19 October 2020

Subject: Catherine Field Public School Modification 1 - Operational Readiness and retaining wall SSD-9477-Mod-1 - Request for Additional Information

Figure 1: Mod 1 plans showing location of retaining wall.

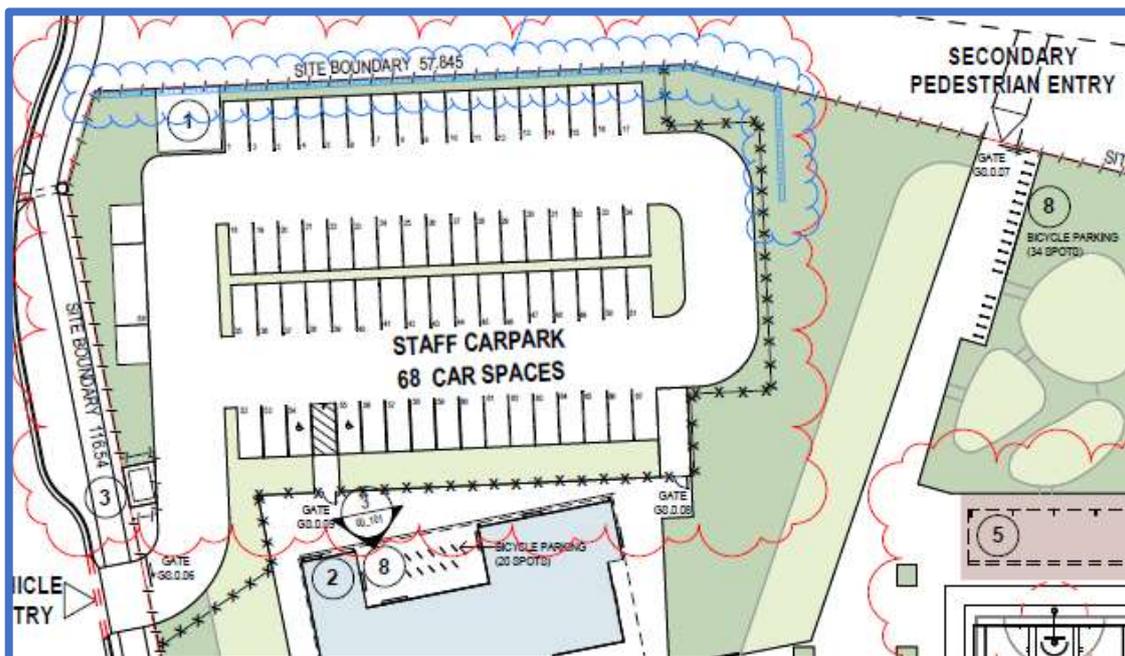
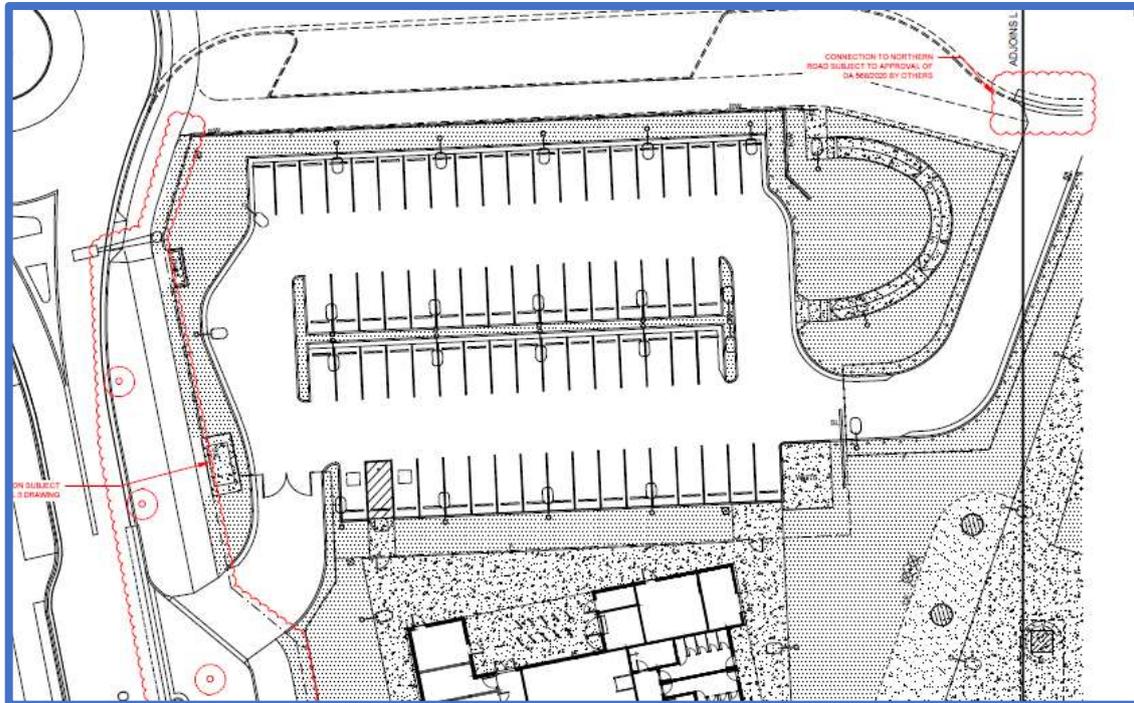
Retaining Wall – Ensure No Conflict with Mod 2

It should be noted that the retaining wall has previously been approved as part of SSDA 9477. The inclusion of the retaining wall in Modification Request 1 was to clarify the necessity of the retaining wall to ensure timely construction of the car park for D1T1 without the reliance on the Northern Road being completed. This retaining wall is temporary in nature and DA 568/2020 submitted by GDC indicates that the levels of the road will tie into the height of the retaining wall. For clarity, the details for the retaining wall in question is consistent in location, height and length across both Mod 1 and Mod 2.
